From: JohnP Holmes
Sent: 02 October 2023 15:58
To: JohnP Holmes
Subject: FW: 2022/92799 17, Town Gate, Upperthong, Holmfirth.

From: Mark Berry <Mark.Berry@kirklees.gov.uk>
Sent: Monday, October 2, 2023 9:19 AM
To: JohnP Holmes <JohnP.Holmes@kirklees.gov.uk>
Cc: Highways DevelopmentControl <Highways.DevelopmentControl@kirklees.gov.uk>; Ryan Kinder <Ryan.Kinder@kirklees.gov.uk>
Subject: RE: 2022/92799 17, Town Gate, Upperthong, Holmfirth.

The highways consultation response dated 27th September considered that this application provided insufficient information and asked that swept paths be provided to demonstrate that a vehicle can enter and exit the site from Towngate.

Number
 4416-07-04
 Date
 09/2023
 Scale @ A1
 As Marked

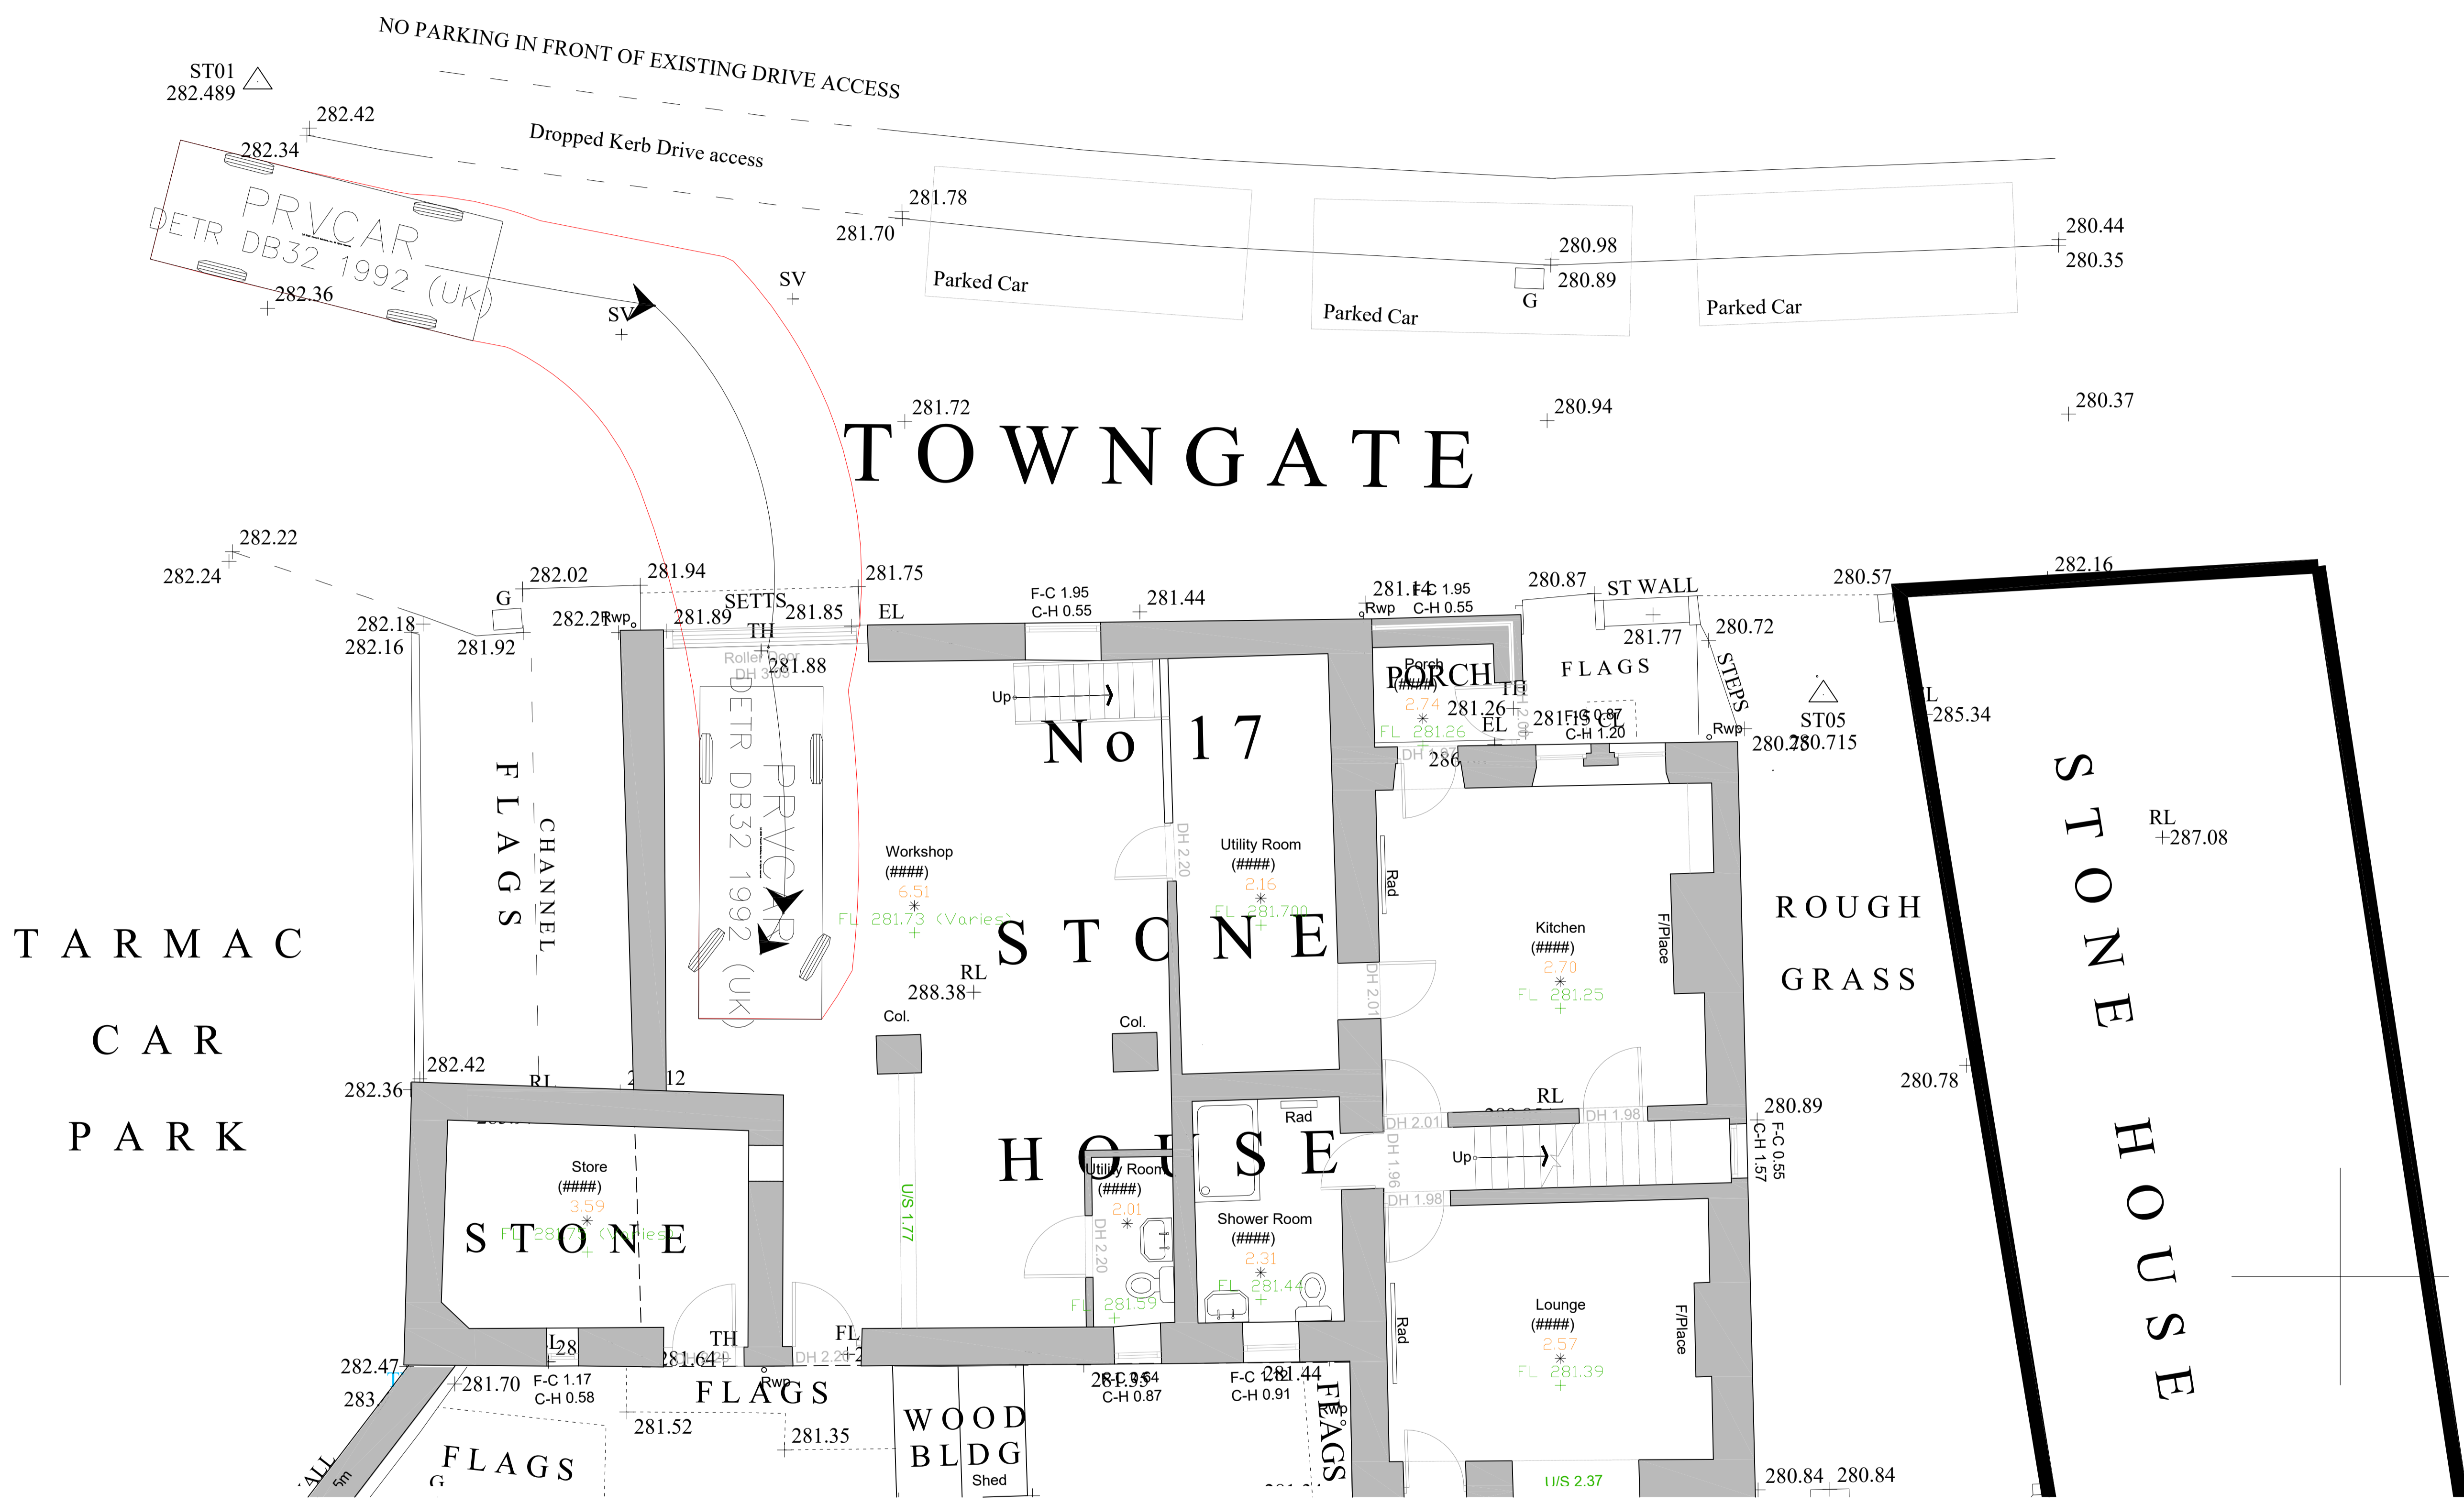
The applicants have now provided 2 further plans showing swept paths, plan number 4416-07-04 showing vehicle turning movements from the west with parked car along Towngate and plan number 4416-07-02 showing turning movements with no parked cars along Towngate.

Whilst the turning movements are tight the details provided demonstrate that access and egress from the proposed access is possible and Highways Development Management have therefore no further objection to these proposals.
